**RE: Cottonweed Mall Exterior Renovation
Grading Plan and Drainage Report
Engineer's Stamp Date: 02/26/18
Hydrology File: B15D004F**

Based upon the information provided in your submittal received 02/28/2018, the Grading Plan and Drainage Report **are not** approved for Building Permit. The following comments need to be addressed for approval of the above referenced project:

Title GRADING AND
DRAINAGE PLAN
Drawn KPW
Reviewed RAT
Scale As Noted
Authorized For REVIEW

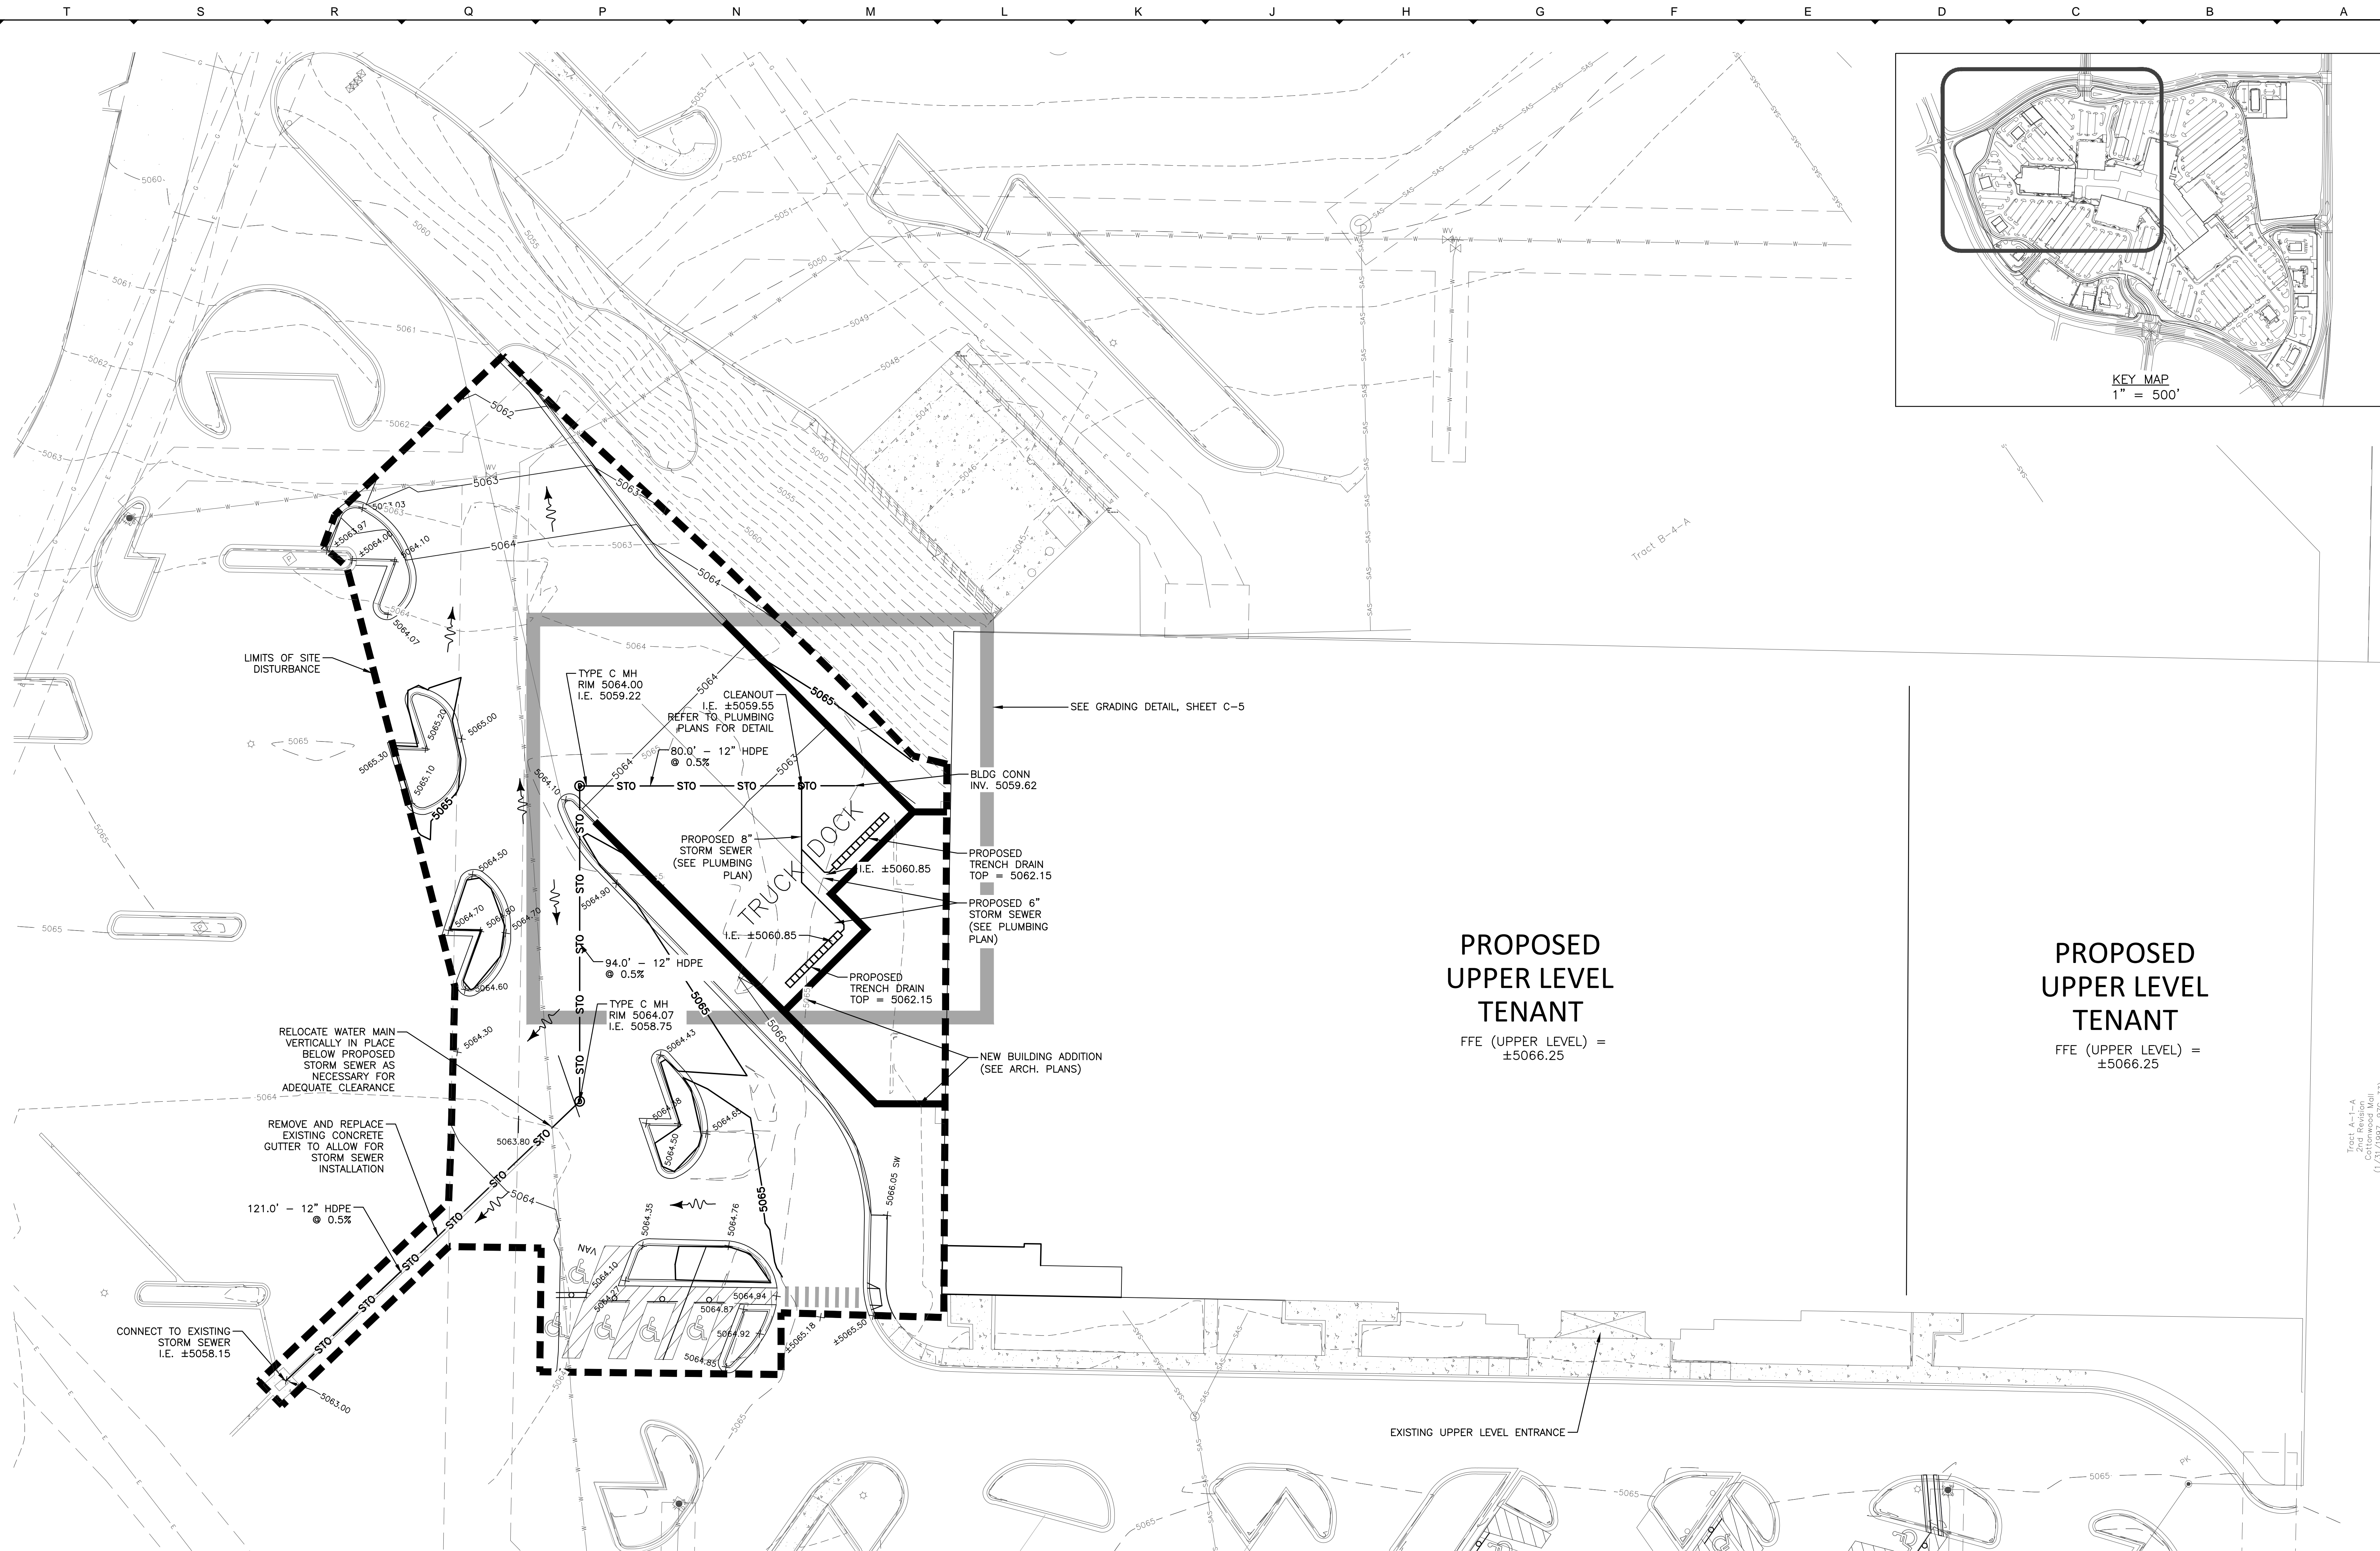
1. Please provide an engineer's stamp with a signature and date.
2. Please provide the FIRM Map and flood plain note with effective date.
3. Please provide the benchmark information for the survey contour information provided.
4. The first flush required is 1,192 cubic feet. The Fee in Lieu, then the payment (Amount = 1,192 CF x \$8/CF = \$9,536) for the required first flush volume must be made using the attached City of Albuquerque Treasury Deposit form. The Owner needs to bring three copies to the Building Permits and pay the fee. Then provide Hydrology with one copy showing the receipt. Once Hydrology has the copy of the form, an approval letter will be issued.

5. Please add a note that states a payment for the Fee in Lieu for the required first flush volume will be made instead of building the first flush ponds.
